Re: Project Solis —Tract J Bulk Land Plat for Mesa del Sol Innovation Park II (101605115947920604)
Project No: PR-2022-007805 (Third Submittal); SP-2025-00084
EPC Plan No: FP-2025-00004

On behalf of Project Solis, Stantec Architecture Inc. respectfully submits this supplemental submission of minor design revisions for final DFT review and approval. The proposed substitutions adhere to the preliminary approvals and findings stated in the EPC *Official Notice of Decision*, dated Aug. 21, 2025 (Plan# FP-2025-00004), and remain in full compliance with the City of Albuquerque IDO codes and regulations. The following revisions have been submitted concurrently to Mesa Del Sol ARC for Step II amendment review and approval.

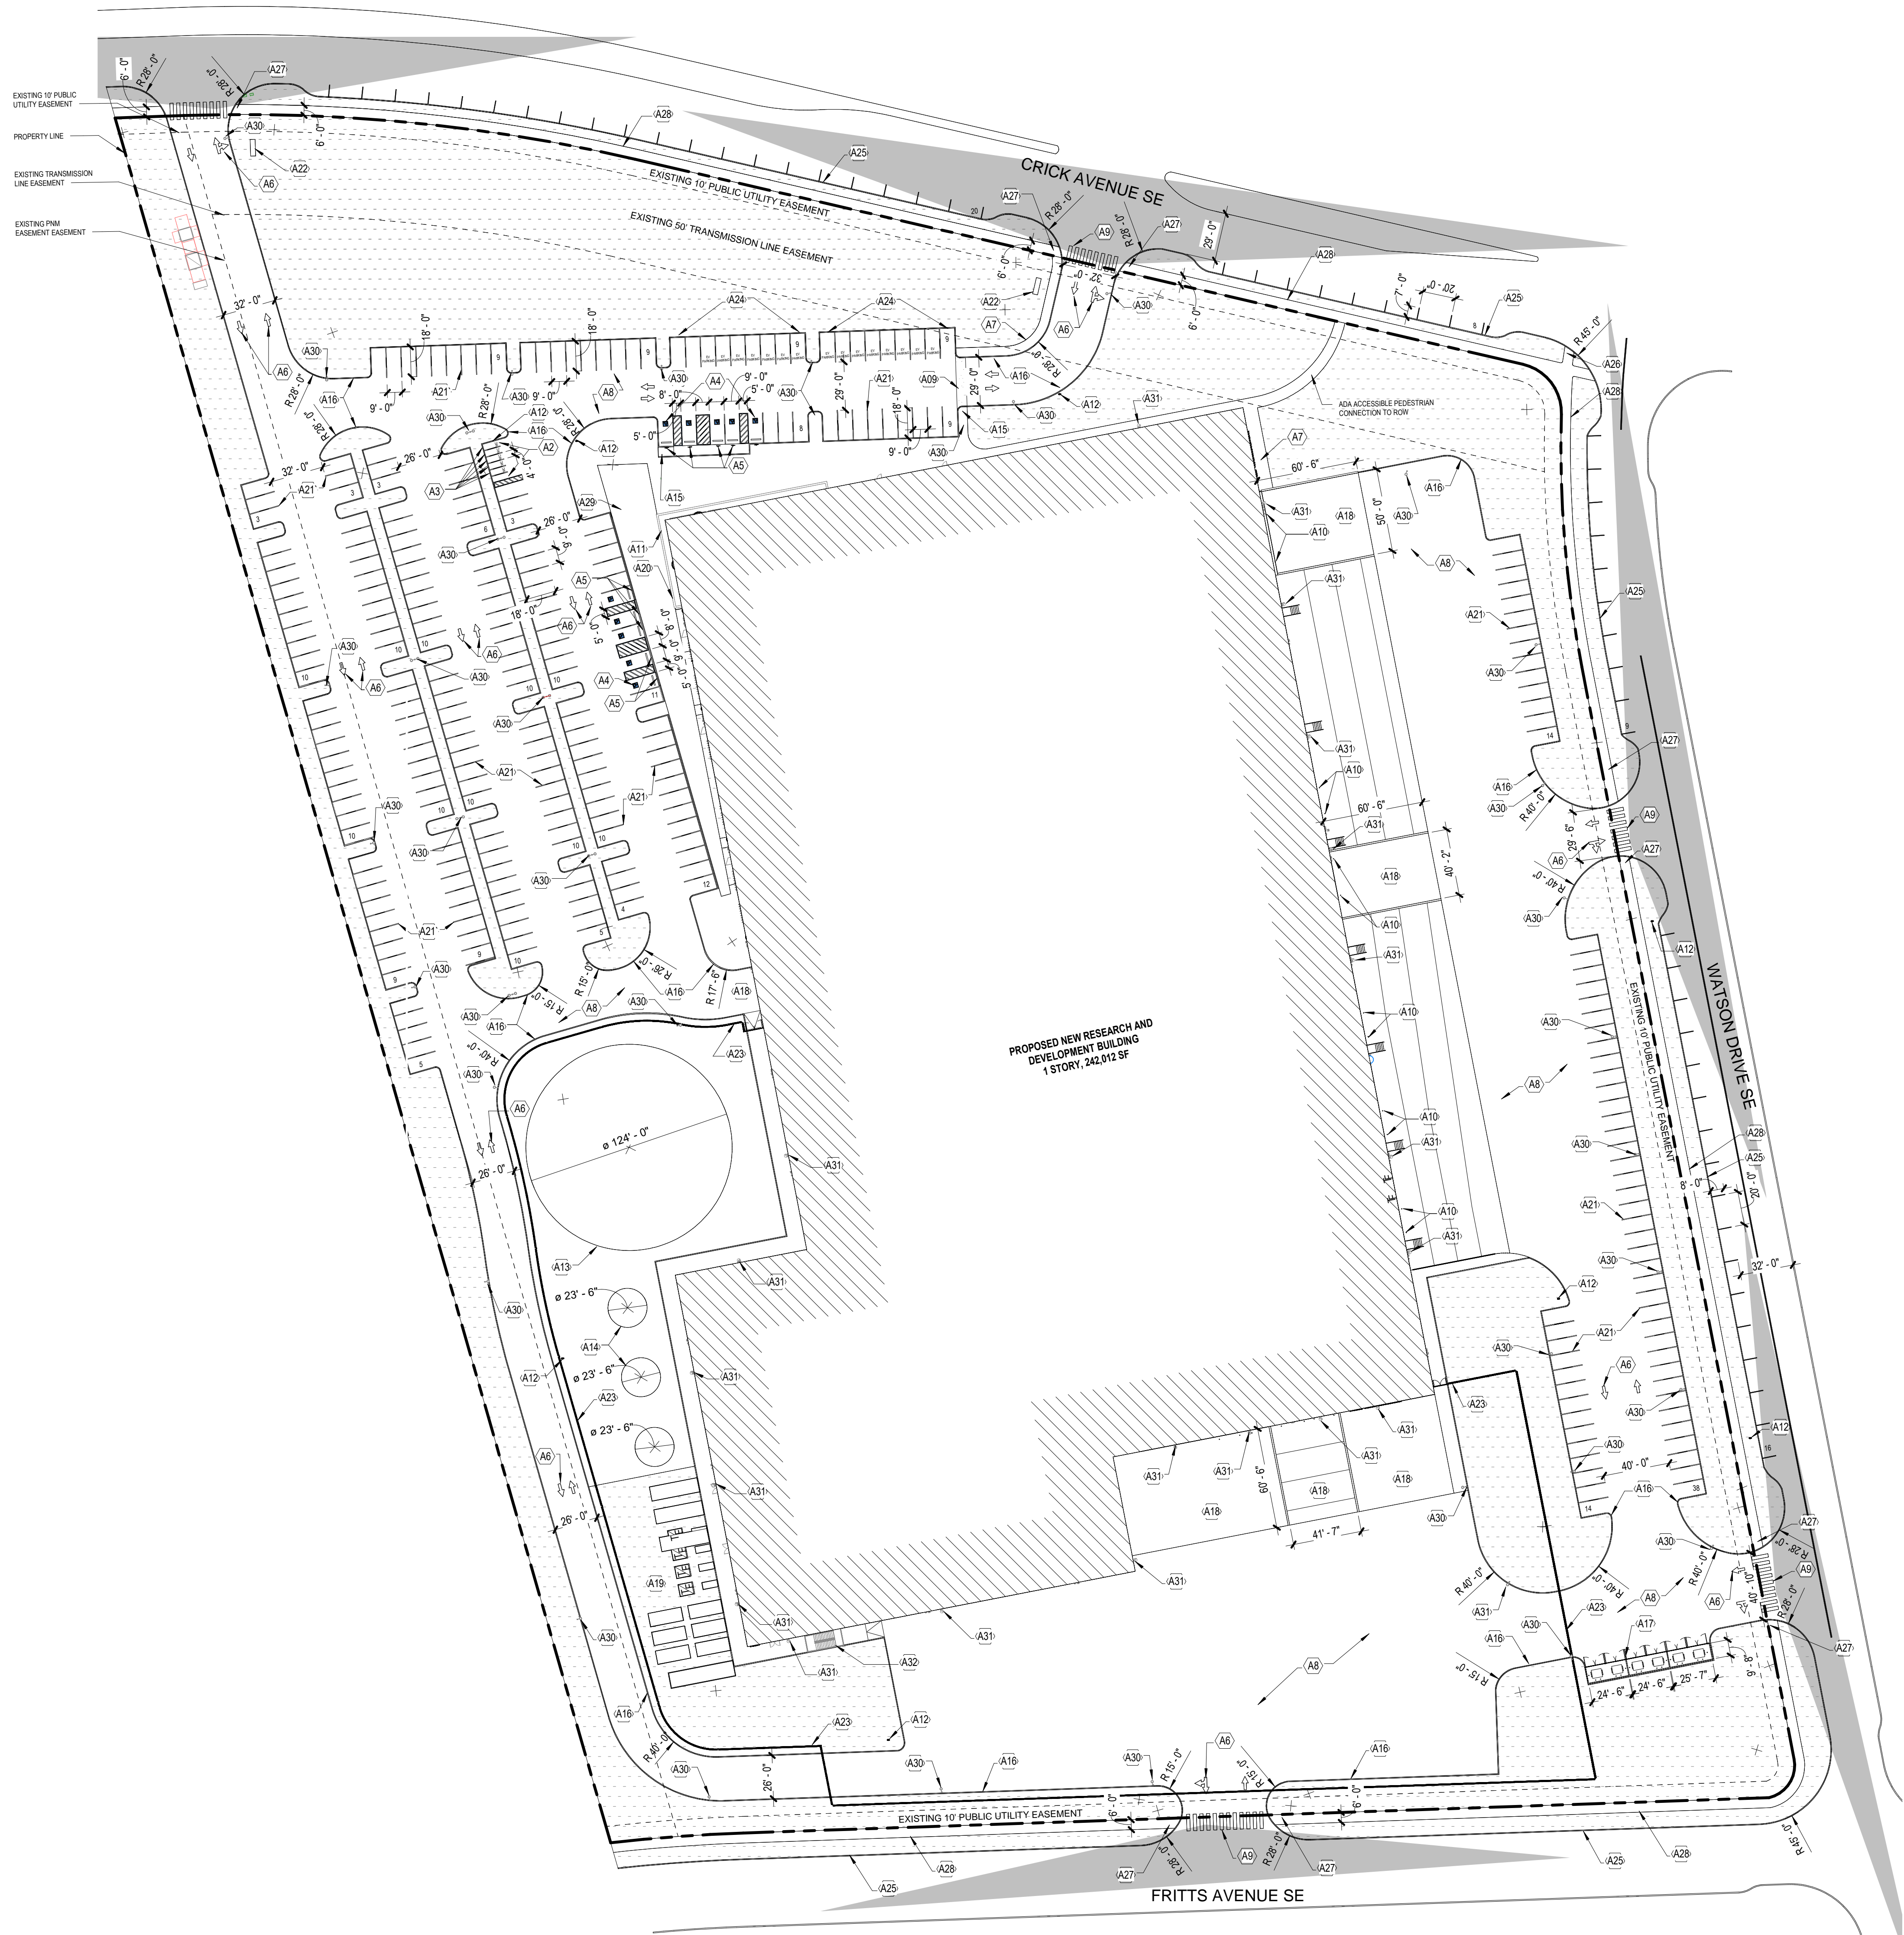
Overall Site Plan – The following revisions have been made to the site design and associated drawings. Based on the total site area of 17.04 acres, 1.67 acres have been impacted by these design revisions – a change of 9.8%. Overall parking increased from 271 spaces to 302 spaces, an increase of 7%. The overall site design was minorly modified to accommodate the larger CUB Facility.

Mechanical & Electrical Equipment Yards – Due to the expansion of CUB, the adjacent site tank yard has been reconfigured. The impervious area, landscaping, fencing and sidewalks at and around the tank yard were affected by this reconfiguration.

Parking Configuration – Parking has been adjusted around the tank yard, and in various locations throughout the site. Additional parking aisles have been added along the western edge of the site, and near the southeast corner of the building. The overall parking count has increased 7%, to 302 spaces.

Loading Ramps at Building – The two truck loading ramps previously shown at the south of the building have been adjusted and increased in size. Two additional truck loading ramps have also been added to the east side of the building.

Trash Enclosure – The trash enclosures have been slightly relocated east, outside of the proposed secure fence line. The capacity of enclosures increased from 4 dumpsters to 6, while the size of the enclosures remains in accordance with City of Albuquerque design standards.

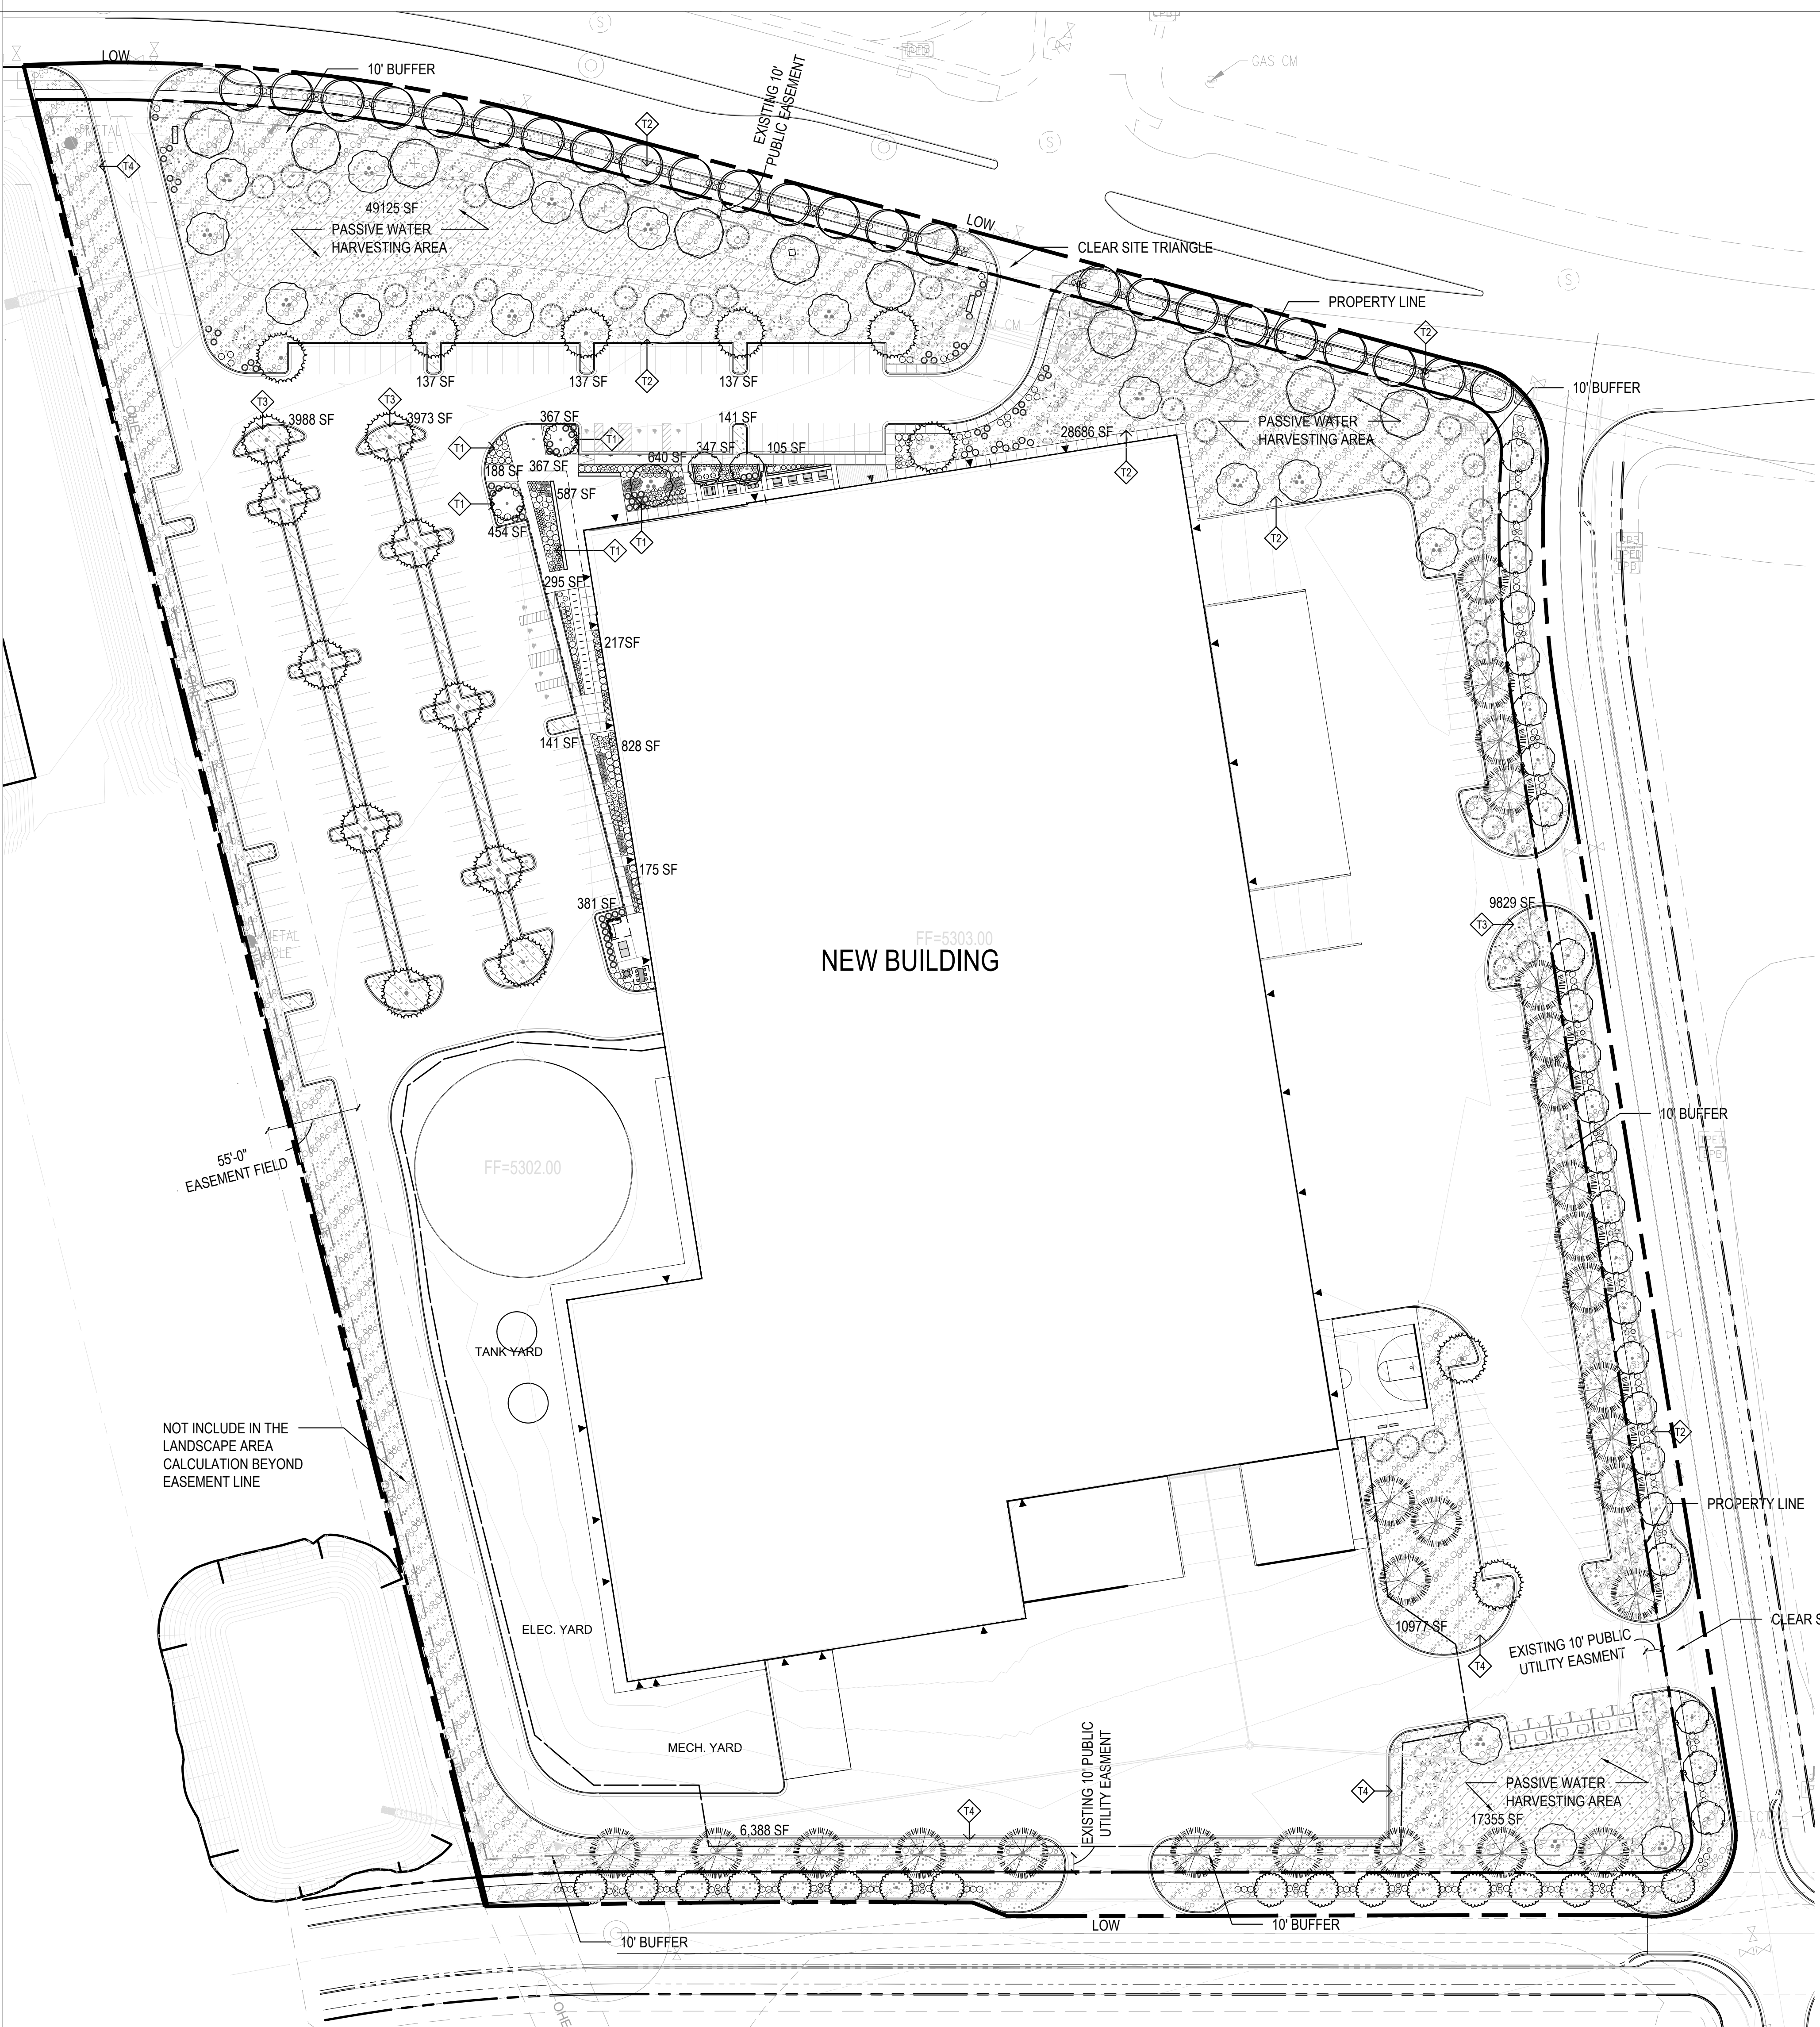
Landscape – Landscape has been reconfigured based on changes to site parking and hardscape. Plant species and coverage remain compliant with City of Albuquerque IDO standards and regulations and Mesa del Sol ARC development guidelines.
